22/03763/SCOP

**Location: Begbroke Science Park Begbroke Hill Begbroke
Kidlington OX5 1PF**

Proposal: Scoping Opinion with respect to the scope and methodology of the Environmental Impact Assessment (EIA) in relation to re-development proposals of approximately 170 hectares (Ha) land at the existing Begbroke Science Park and surrounding land.

Figure 11.1: Designated Nature Conservation Sites

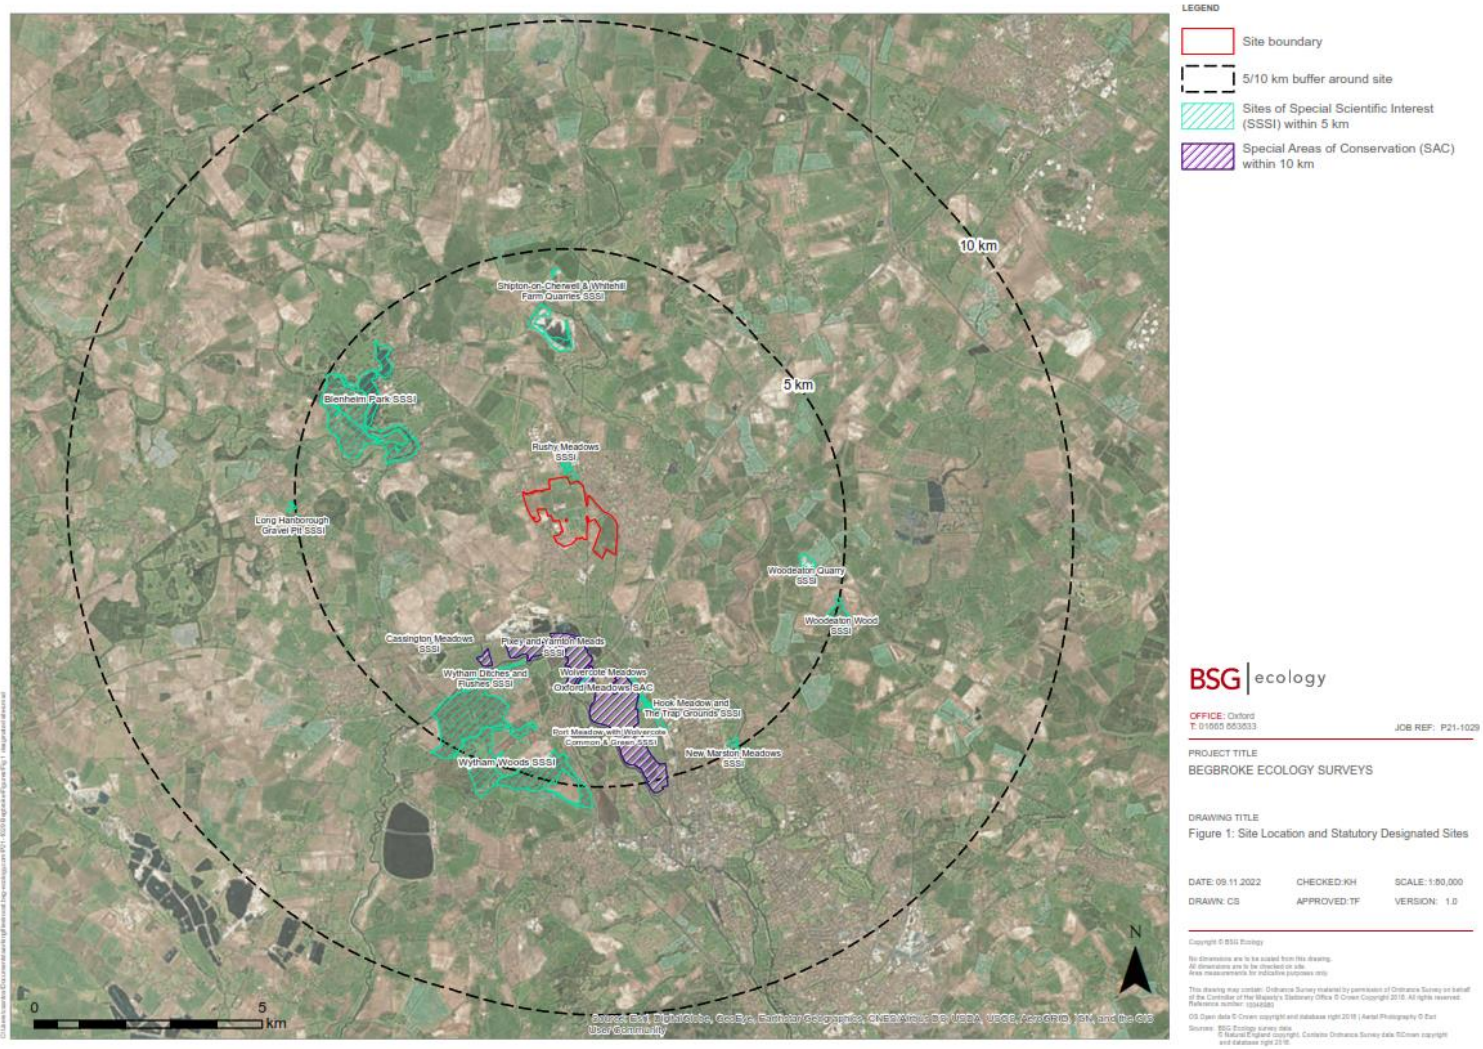
Rushy Meadows SSSI, is located within approximately 10m of the north eastern Site boundary. The SSSI citation for Rushy Meadows states:

Oxford Meadows Special Area of Conservation and Pixey and Yarnton Meads SSSI are located approximately 1.8km south of the Site. Oxford Meadows includes vegetation communities that are perhaps unique in the world in reflecting the influence of long-term grazing and hay-cutting on lowland hay meadows. Pixey and Yarton Meads SSSI are unimproved flood meadows on the bank of the river Thames. They have been grazed and cut for hay for more than a thousand years, with the result that they are botanically rich, with more than 150 species. In addition, there are 17 other non-statutory designated sites and three areas of Ancient Woodland within a 2 km radius of the Site.

Given the ecological sensitivity of this area it is essential that the EIA should include results of appropriate surveys, and an assessment of impact on each designated site. These must deal with potential impacts on both nationally and locally designated sites and how these will be avoided and if they cannot be avoided how the benefits of the development in the location proposed outweigh both its likely impact on the features of the designated site, and how the impacts will be mitigated.

Figure 11.1: Phase 1 Habitat Survey Map

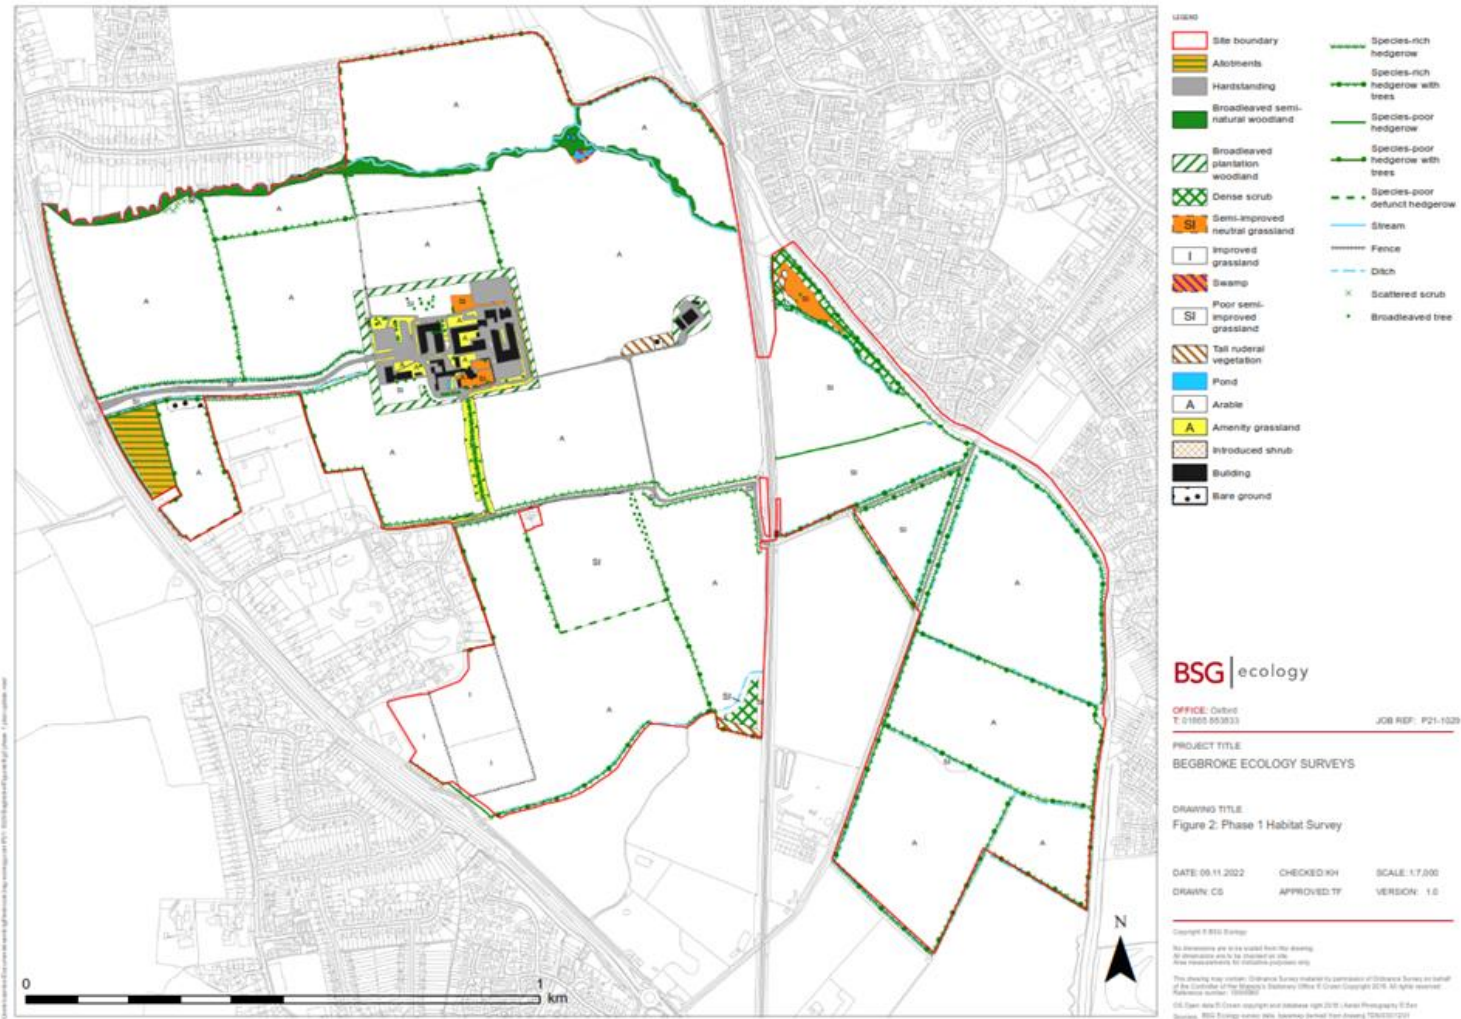
The site also contains hedgerows, areas of semi-improved grassland, woodland corridors and a pond with great crested newts, all of which are considered Habitats of Principle Importance. The EIA must fully demonstrate the measures which will be taken to ensure that there is no negative impact on these habitats (including hedgerows see below) and any other priority habitats nearby.

Paragraph 11.4 of the applicant’s scoping report notes that bat roosts are present in Begbroke Hill Farmhouse and an adjacent building within Begbroke Science Park, and a range of bat species use the hedgerow network within the Site for foraging and commuting. The pond within the Begbroke Science Park contains a small breeding population of GCN and other protected species identified on-site include water vole, breeding birds (including Species of Principal Importance (‘SPIs’) such as skylark, red kite, and house sparrow), and reptiles. In addition, brown hairstreak butterfly (a SPI) was found to breed at the site.

The EIA should include results of appropriate surveys, an assessment of impact, and details of mitigation, compensation and enhancement measures. These must deal with impacts on priority species (including breeding birds see below) on site and any priority species nearby.
